**Consultation Response from KC,
Lead Local Flood Authority**

2024/91023 Land Off, Woodhead Road, Brockholes, Honley, Holmfirth

Erection of 4 dwellings with landscaping and associated infrastructure

Date Responded: 21st May 2024

COLOUR KEY

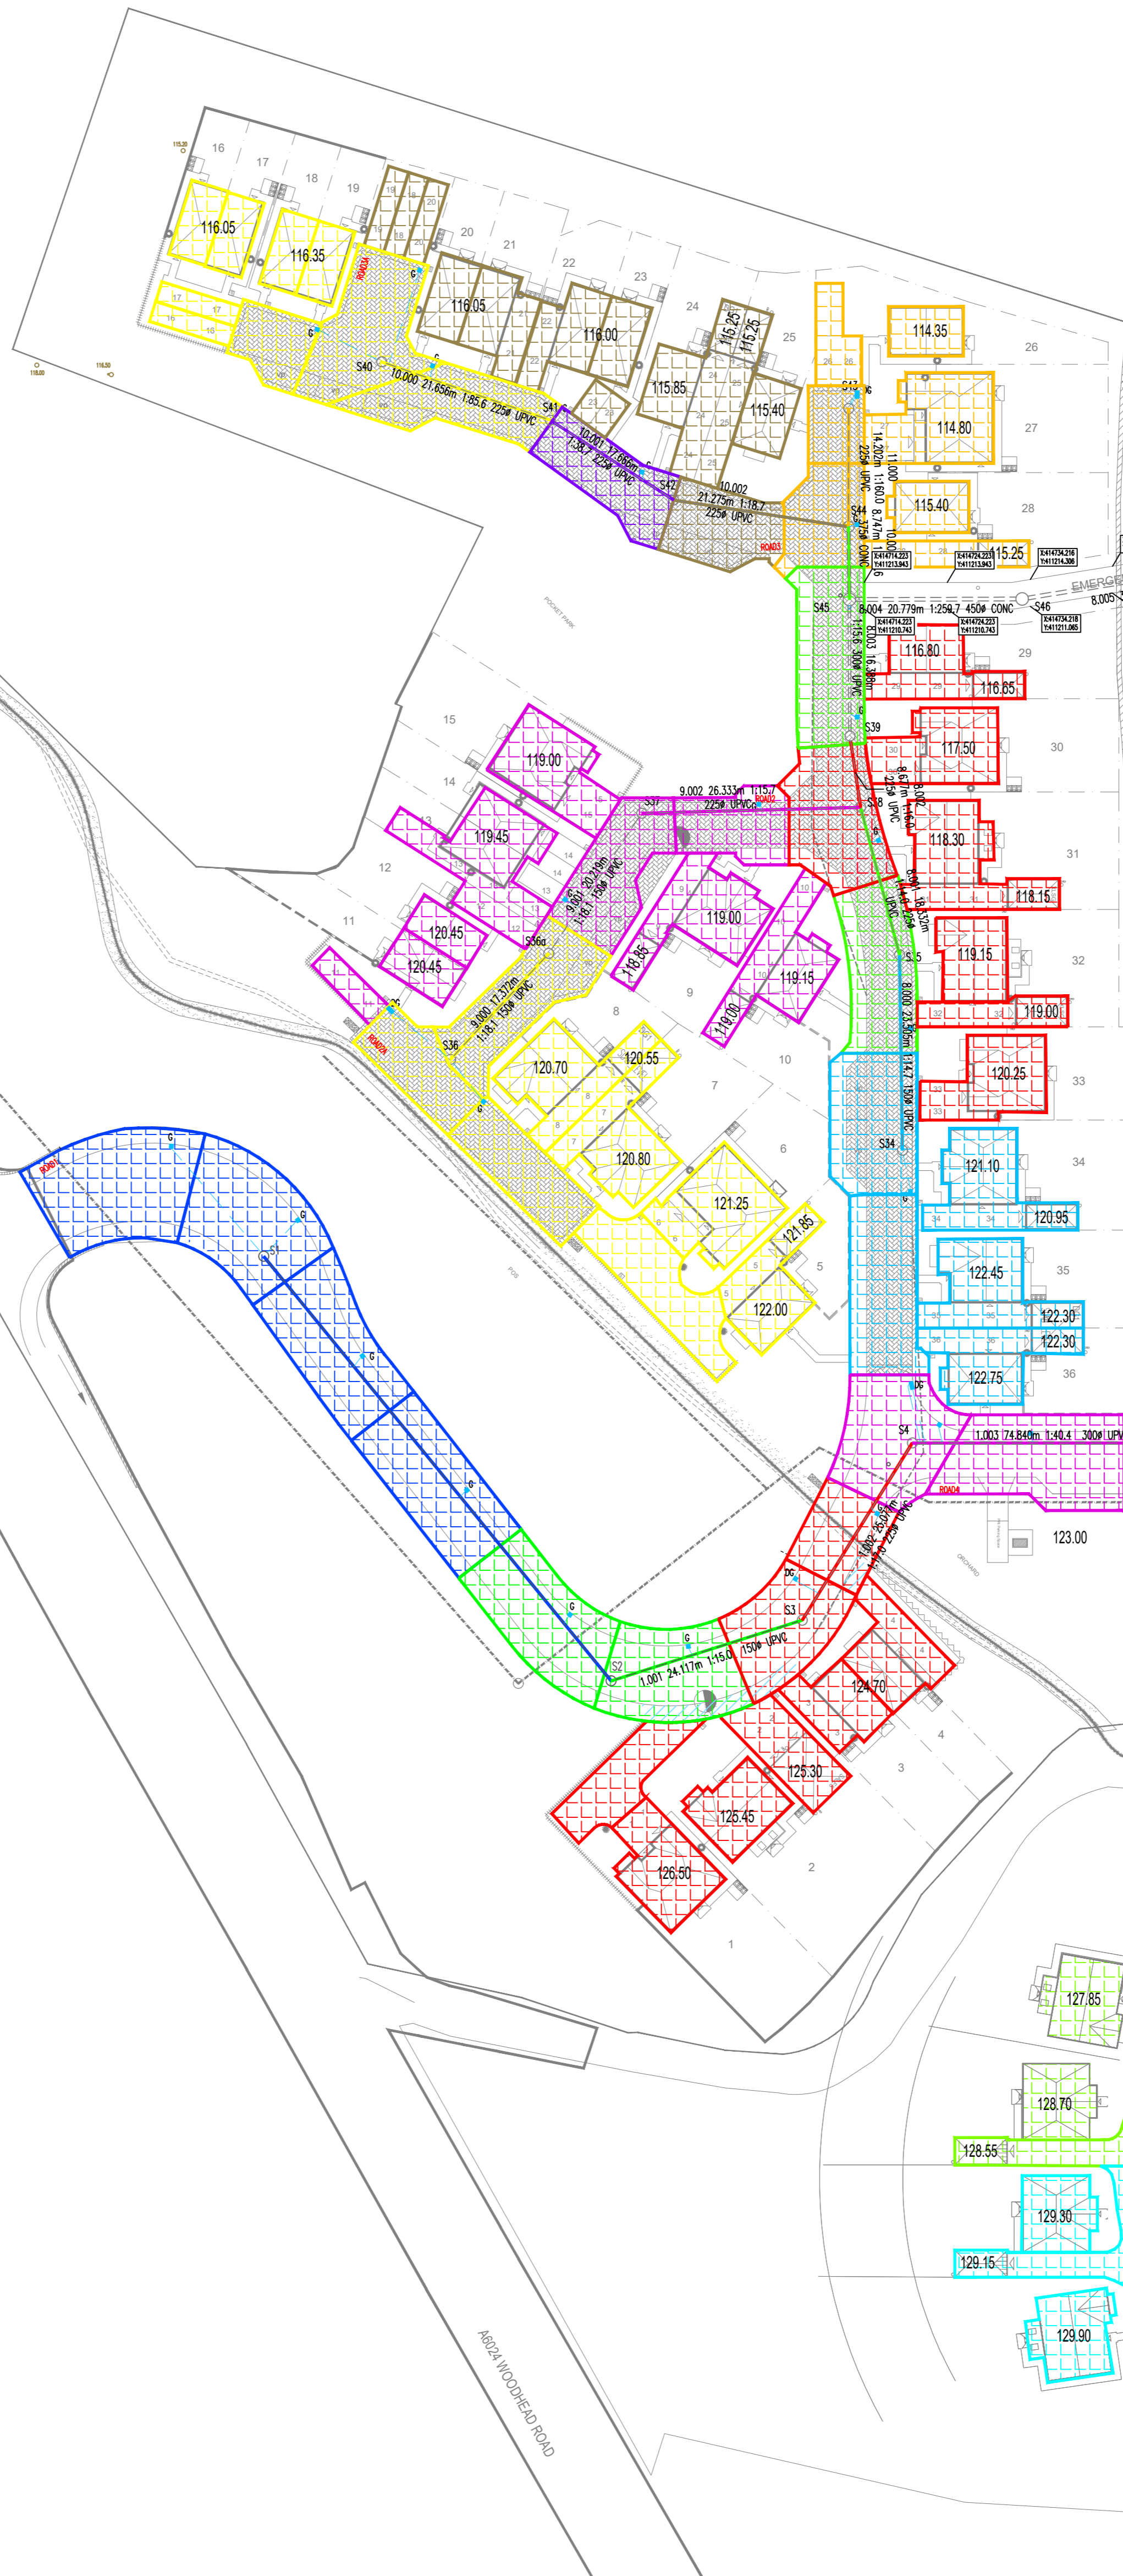
However, due diligence is required for a surface water simulation model for the 1 in 1, 1 in 30 and 1 in 100+30% surface water drainage scheme. Microdrainage outputs should be updated to include the new plots with a coloured drawing showing contributing areas to relevant named individual sewer legs to cross reference with the hydraulic calculations.
